R/93/20/HH & R/94/20/L

Listed building consent for the demolition & erection of conservatory.

Drawing: Proposed Elevations, Plans and Roof Plan

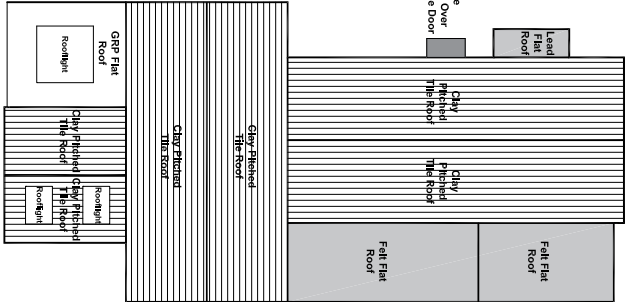
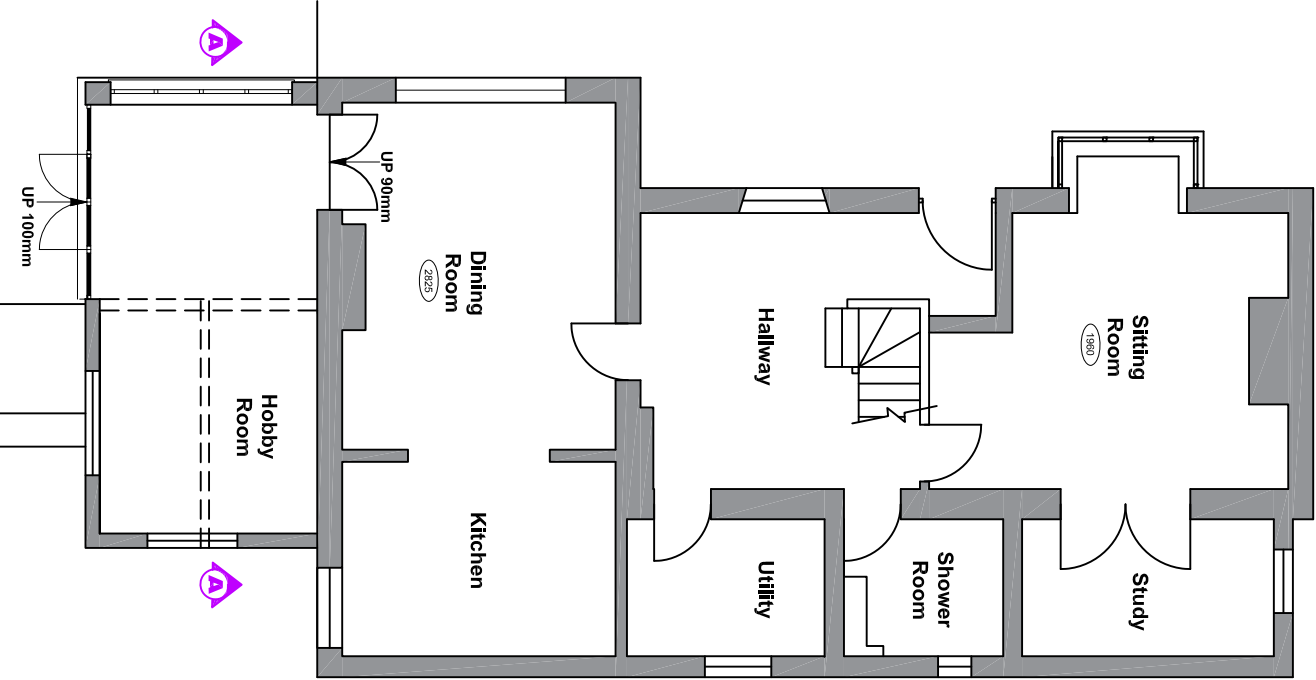
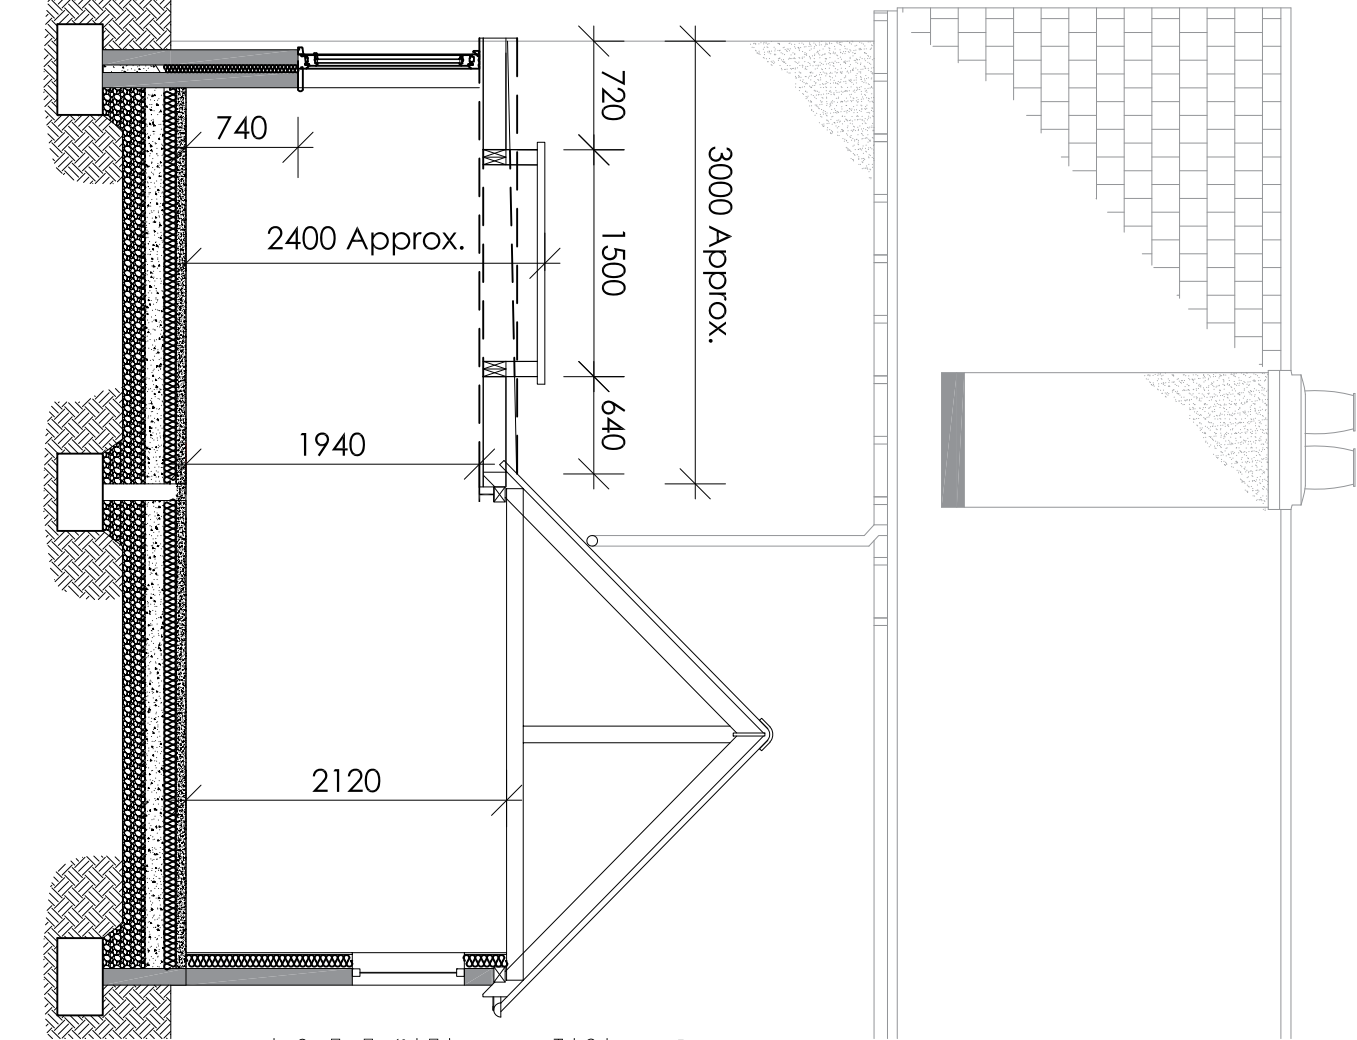
The proposal is for the demolition of an existing conservatory and for its replacement with a small, single storey extension with rooflight. The existing conservatory is not appropriate for the listed cottage and its removal will have a positive impact. Further, it is considered that the proposed design appears to be suitable for the host building, being simple in appearance. Of note is the fact that the East elevation (front) windows will match the design of the existing building, and that the existing flint and brick base wall will be used as part of the proposal. Traditional materials for the windows are preferred, but details can be provided for by way of condition, if you are minded to approve the applications.

The rooflights on the 1910 extension should be of conservation standard; flush mounted with a vertical glazing bar.
